From: Grant, David
Sent: 30 November 2023 11:41
To: _planningadvice
Subject: FW: Site off Stephenson Avenue H14-0897-23

Please add this email to the DIP under 6SUP – Meter cabinet and concrete platform dimensions.

From: Grant, David
Sent: 29 November 2023 18:12
To: michael@murrayplanning.co.uk
Subject: Site off Stephenson Avenue H14-0897-23

Proposed East Elevation
(Scale 1:200)

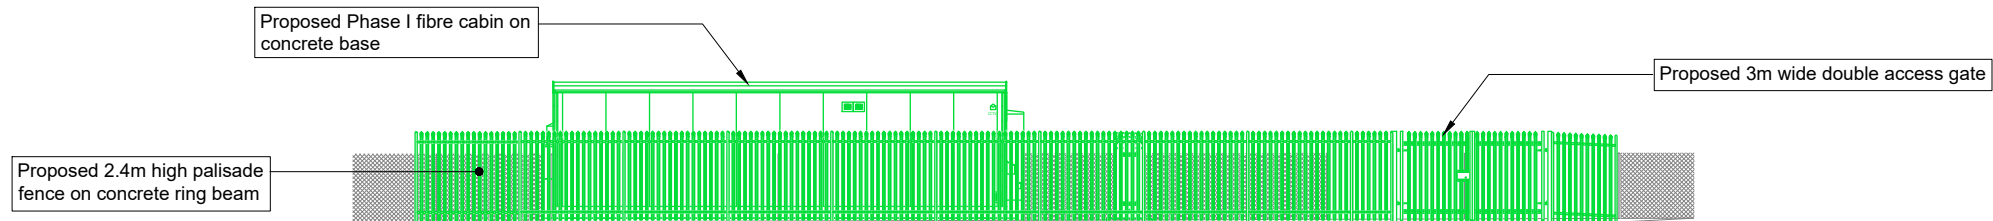
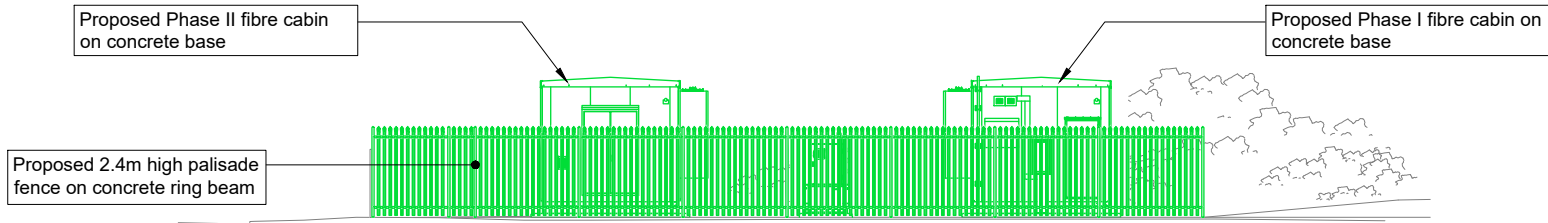
One quick question. Can you please confirm the height of the meter cabinet on the proposed site plan, and the height of the platform on which it sits?

Meter cab is 2267mm but will need to be on a 450mm base due the FRA requirements.
